**SUPPLEMENTAL MEMORANDUM**

November 2, 2022

RE: Toll 44<sup>th</sup> Street NE Marysville – Response to City Comments  
(R.A.I. No. 2021-056-101)  
City of Marysville File No. PA22-024

This memorandum has been prepared in response to comments provided by the City of Marysville in a letter dated August 17, 2022 and via email on October 27, 2022 regarding the Wetland Delineation & Buffer Enhancement Plan for the Toll 44<sup>th</sup> Street NE project (Raedeke Associates, Inc. 2022).

FIG 2
 SHEET
 1 OF 4

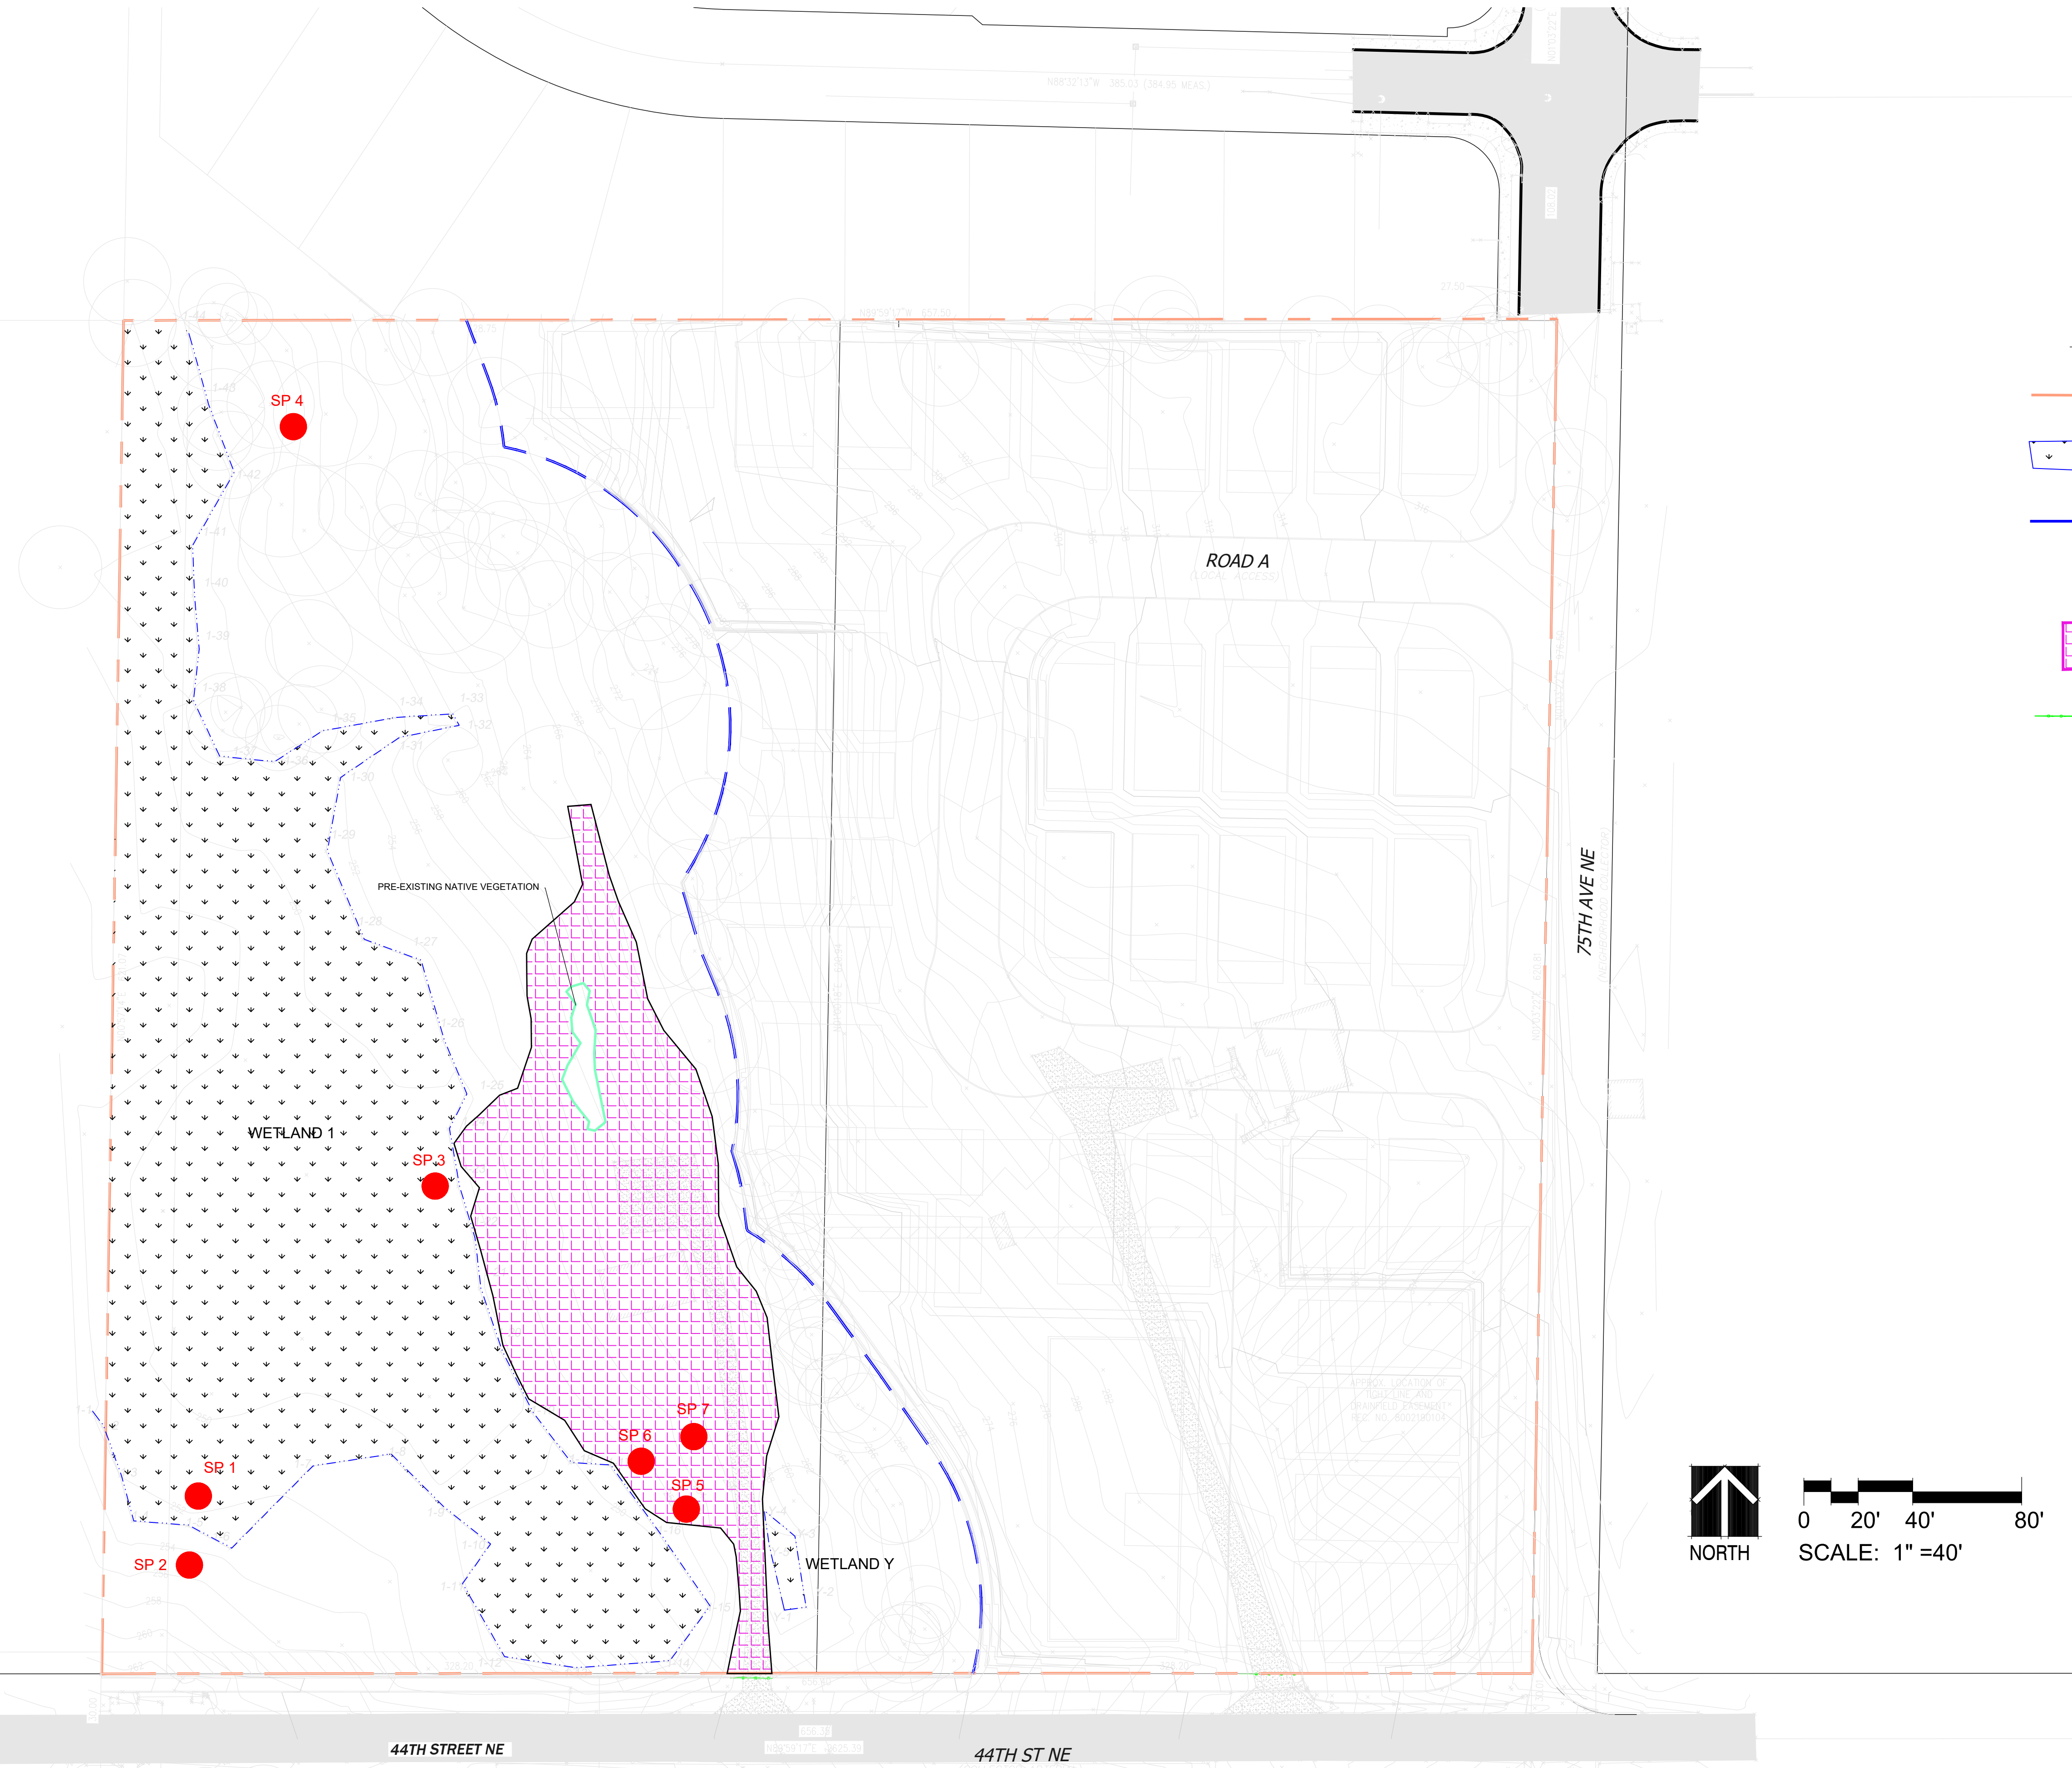
Section 5.1 on page 8 of the report (RAI 2022) states that no direct impacts to wetlands are proposed by the project. However, Section 5.2 describes road frontage improvements along 44<sup>th</sup> Street NE required by the City of Marysville. These road improvements constitute direct impacts to the wetland buffer but are considered indirect impacts to the wetland. The road improvements would permanently impact an estimated 8,800 square feet of buffer area, along with an additional 2,200 square feet of temporary impacts, per calculations provided by D.R. Strong.

The buffer enhancement plan has been updated to show the split rail fence and critical area signage around the wetland buffer and along 44<sup>th</sup> Street NE (see Sheet 2 of attached sheets). The split rail fence may need to include openings or gates to allow maintenance access to the buffer enhancement area from 44<sup>th</sup> Street NE and openings where the split rail fence may intersect with any proposed trails.

To mitigate for the 8,800 square feet of permanent buffer impact, approximately 26,582 square feet of buffer enhancement is proposed for what is currently degraded buffer. The enhancement area greatly exceeds the area of impacts. Enhancement will include removal of the residential structure, gravel driveway, and invasive species, followed by replanting the degraded areas with native trees and shrubs. The enhancement plan is further described on pages 11 – 16 of the report (RAI 2022).
